Ref: 6/2021/1791/VAR
Date: 17/08/2021

HISTORIC BUILDINGS AND CONSERVATION ADVICE

RE: *Nyn Manor, Vineyards Road, Northaw, Potters Bar, EN6 4PQ*

The application is for the variation of condition 4 (approved plans) on planning permission 6/2019/1813/FULL.

MACHINERY SHED: OLD BARN ELEVATION

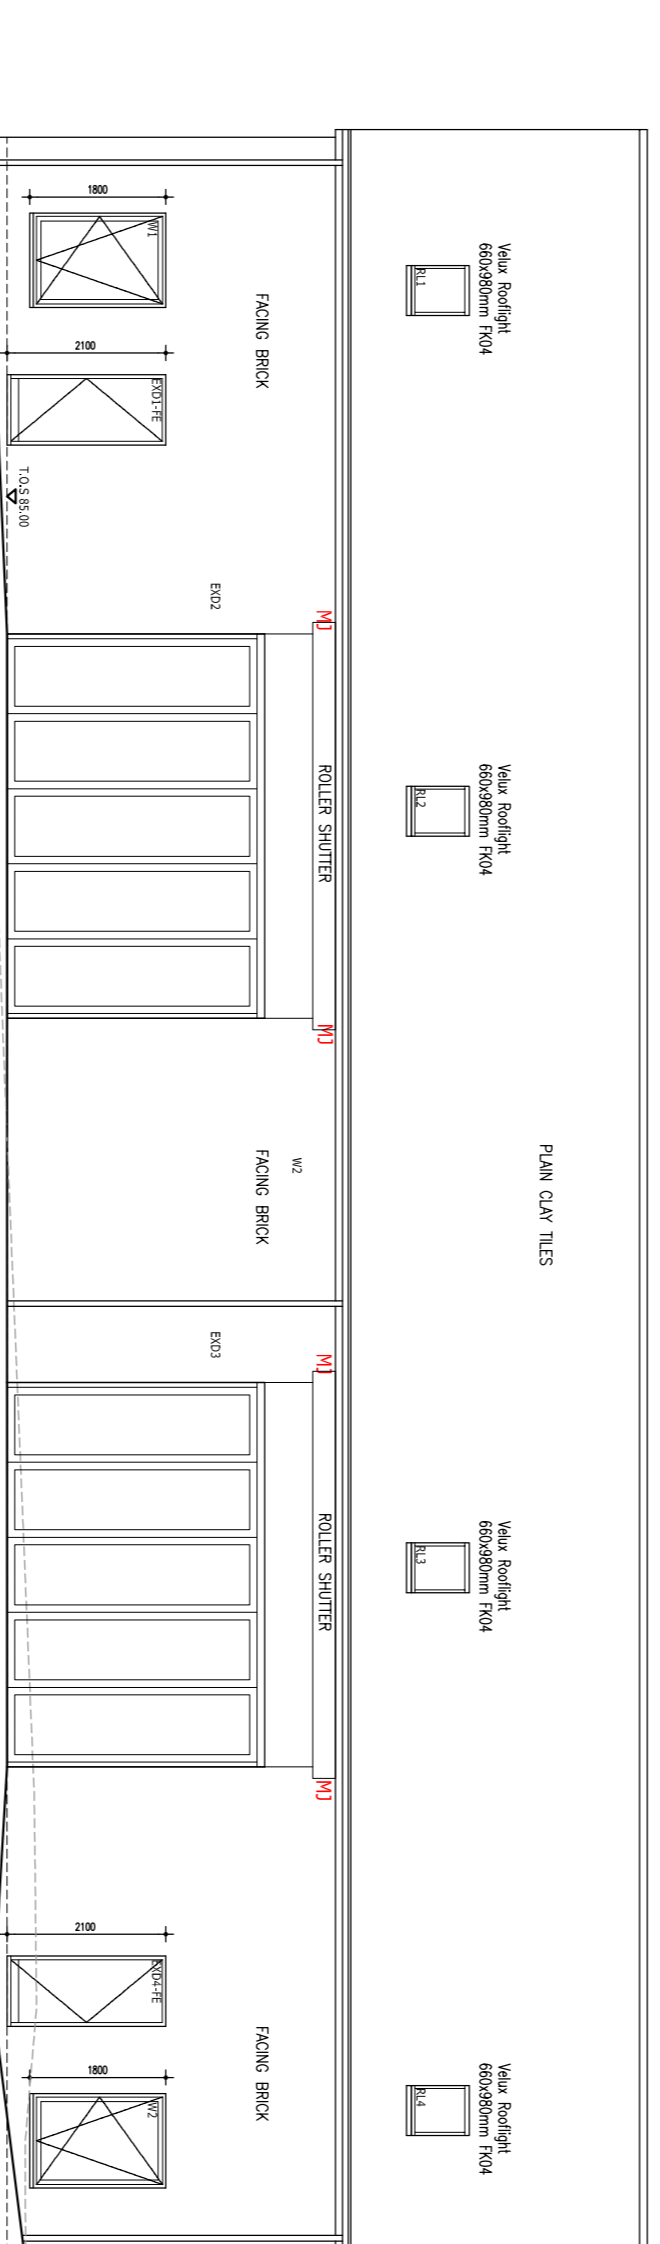
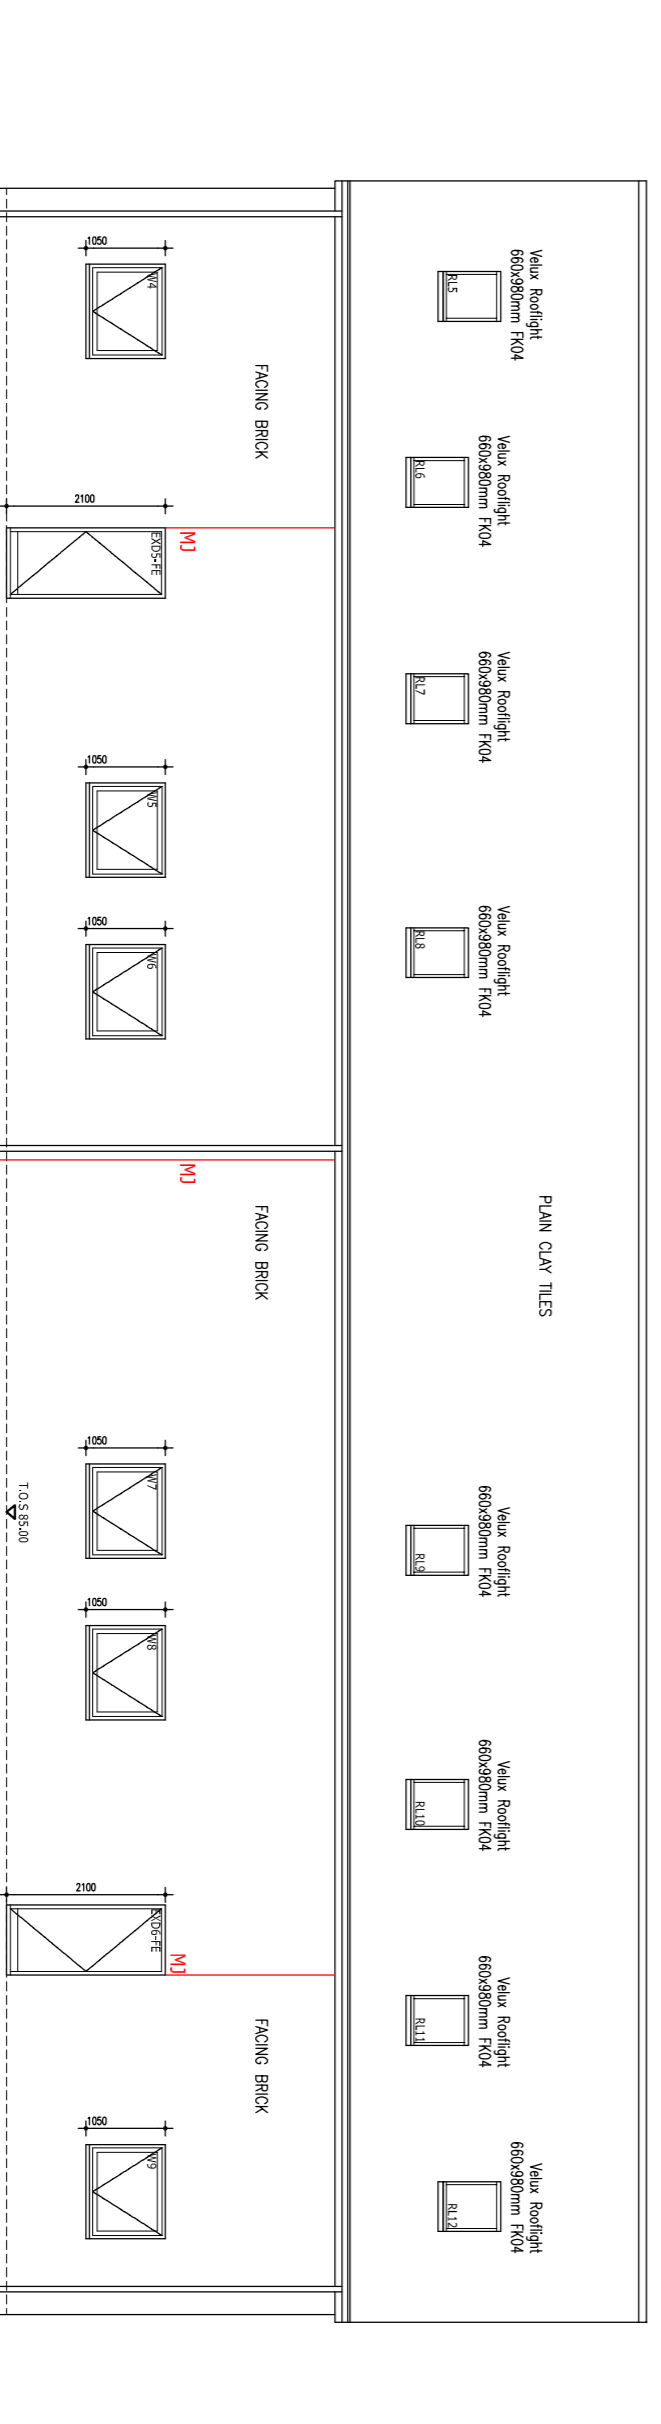
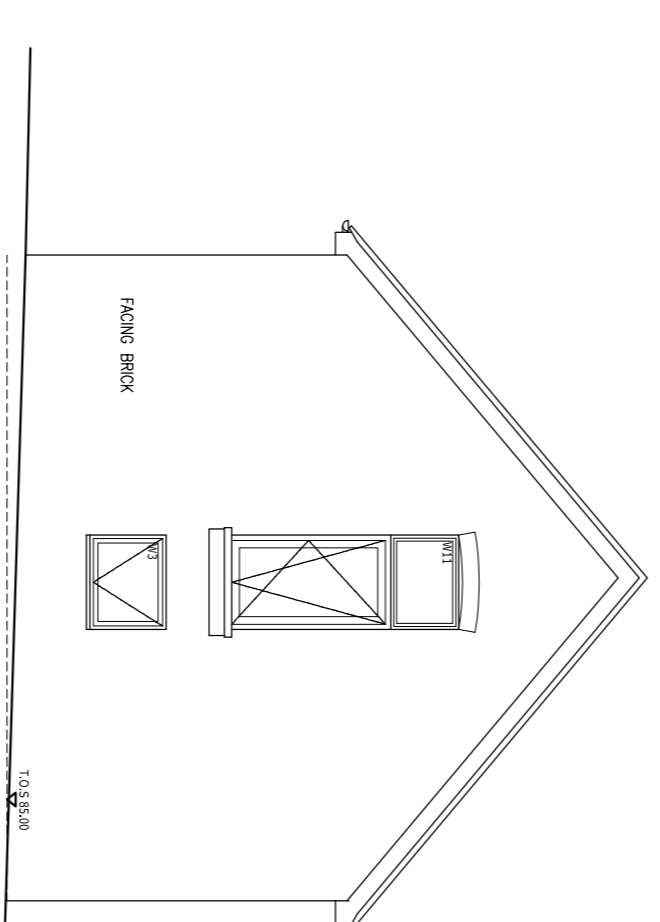
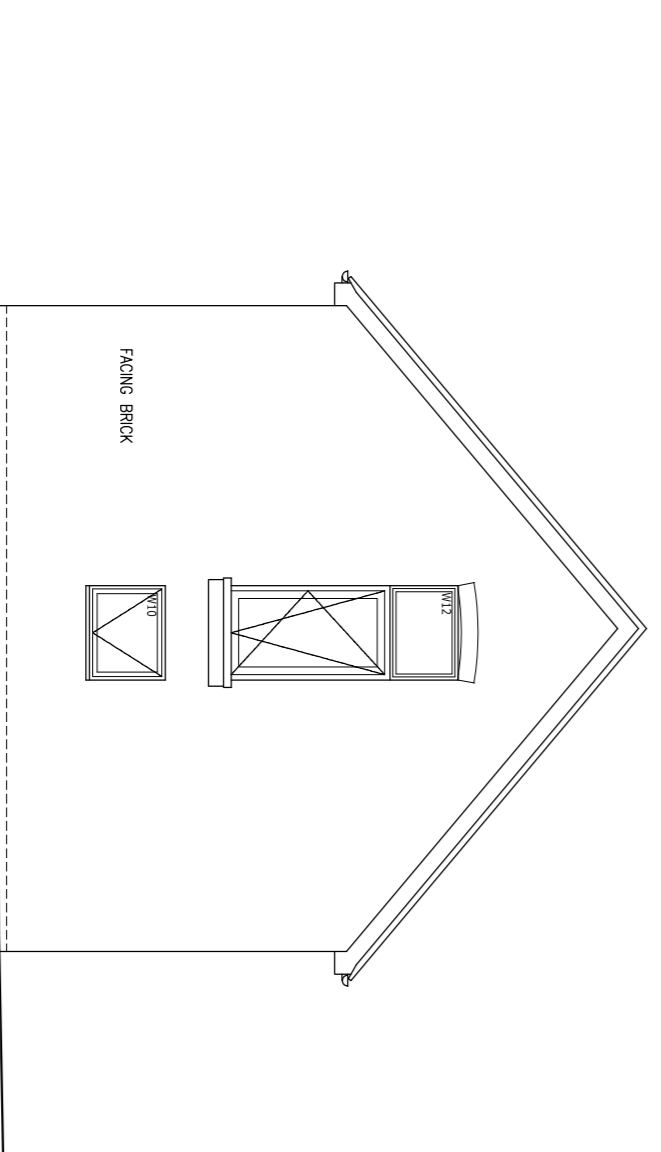
There are no objections to the changes to the elevations, however, there remain concerns that the number of rooflights results in a cluttered roofslope facing the listed barn, contrasting with the simple, uninterrupted roof of the barn. The design of the building could certainly be improved by reducing the number of rooflights to avoid the 'peppered' appearance. However, as the other changes to the scheme are acceptable, it is considered that the rooflights alone do not result in harm to the significance of the listed buildings.
